From: Longridge Town Council <longridgetc@gmail.com>
Sent: 10 March 2016 18:45
To: planning
Cc: 'Longridge Town Council'
Subject: Comments on Planning Application 3/2016/0160 - Dog Inn Longridge

Planning Application 3/2016/0160 Change of Use of upper floors to 5 one bedroom apartments including provision of parking to rear, removal of external escape stair and rear porch and re-opening tap room entrance to public house at Dog Inn Market Place Longridge

Ground floor plan

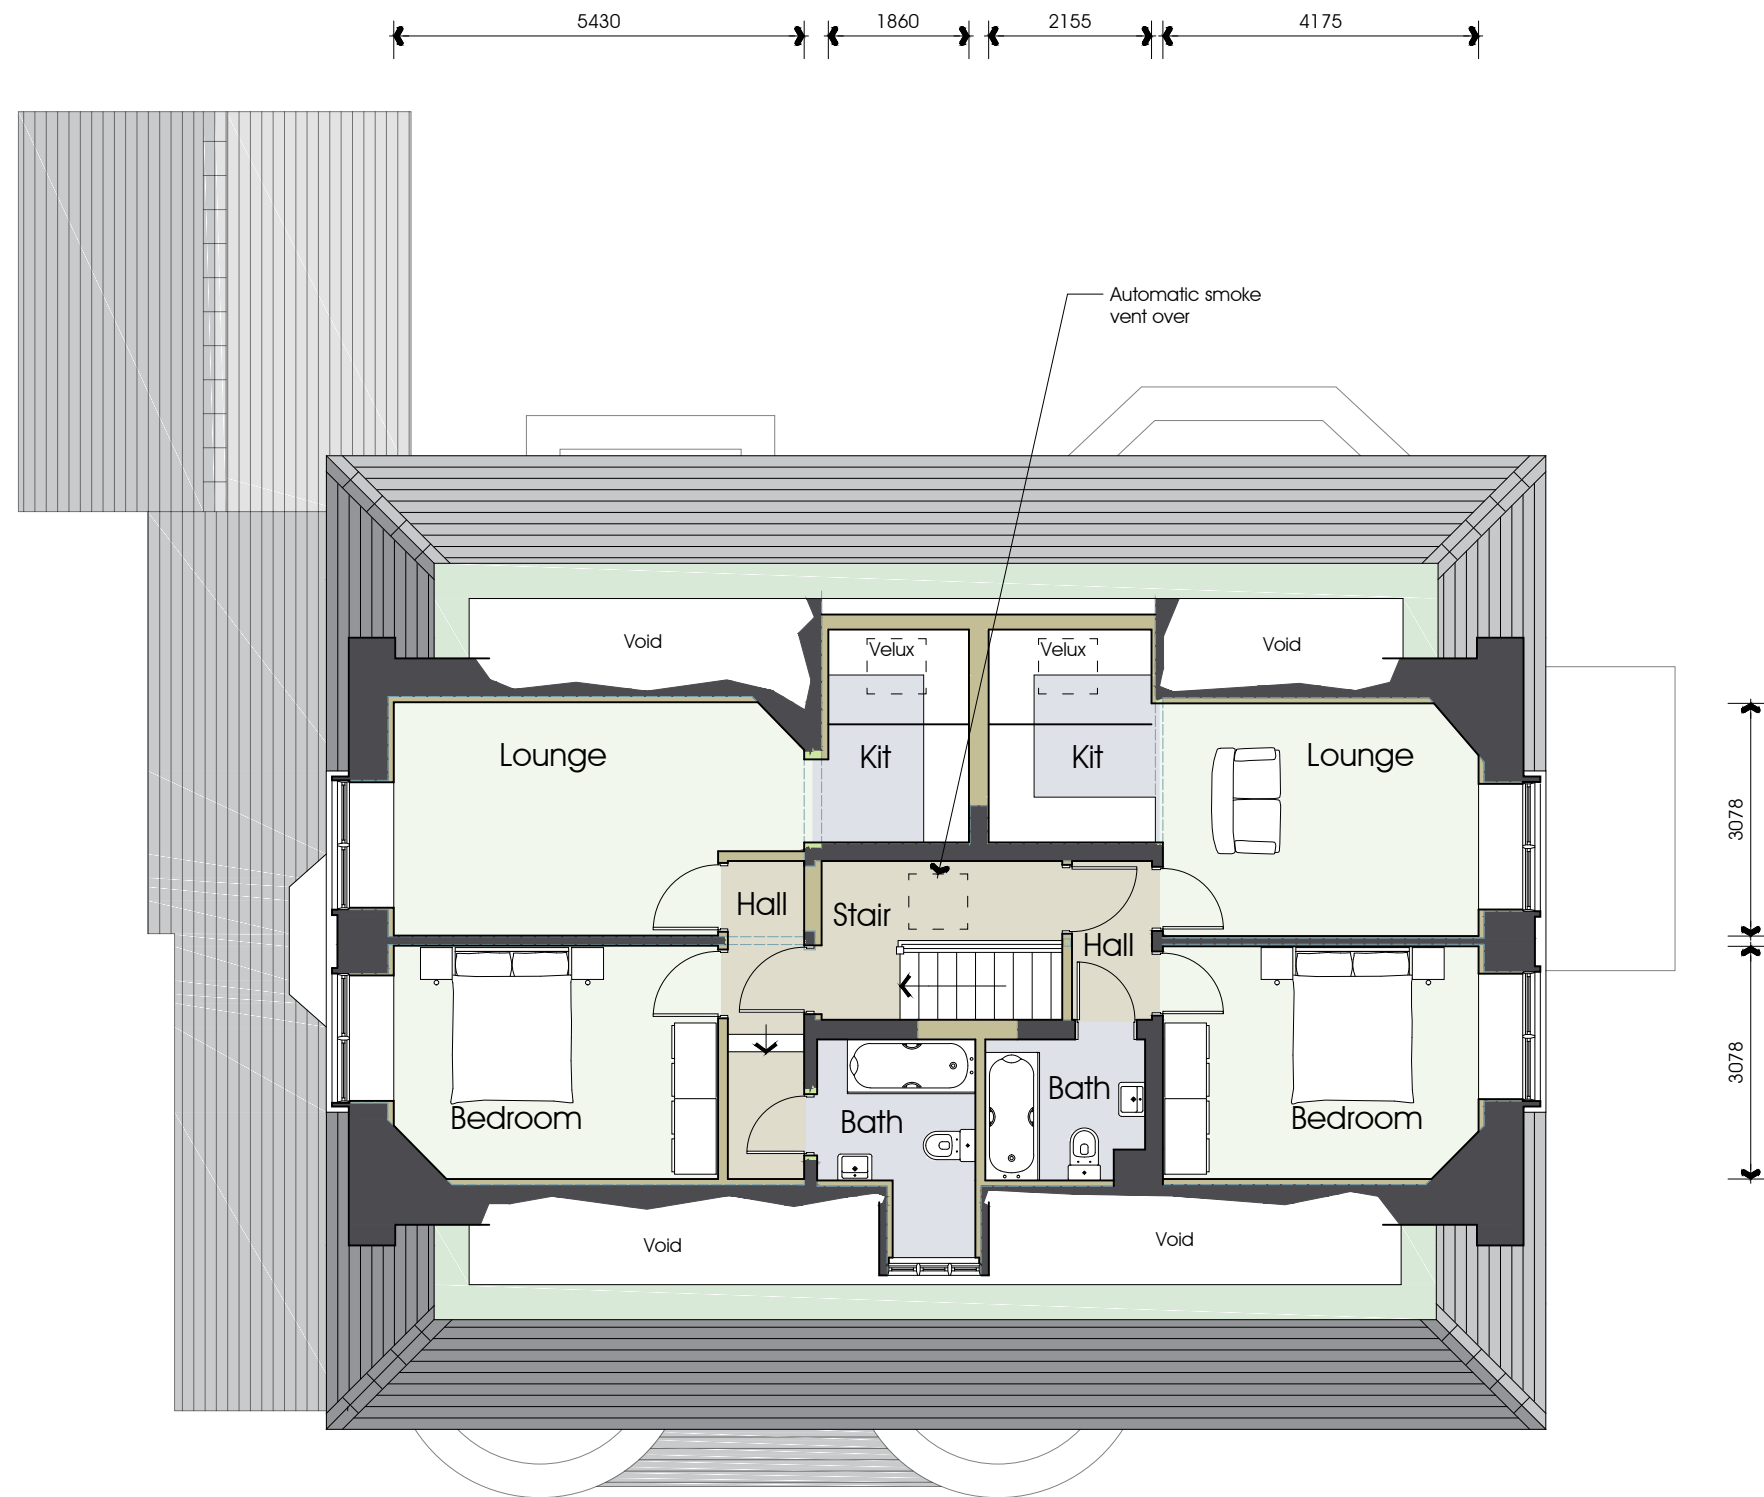
- 1 Parking concerns. Lack of spaces being provided for residents and users of the public house. Already a congested area with limited parking and fear for safety of pedestrians. Concern also about access onto the highway and adequate space for good vehicles delivering to the premises
- 2 The proposed opening of the tap room door onto Swarbrick Court and the effect on residents.
- 3 Lack of consultation with local residents.
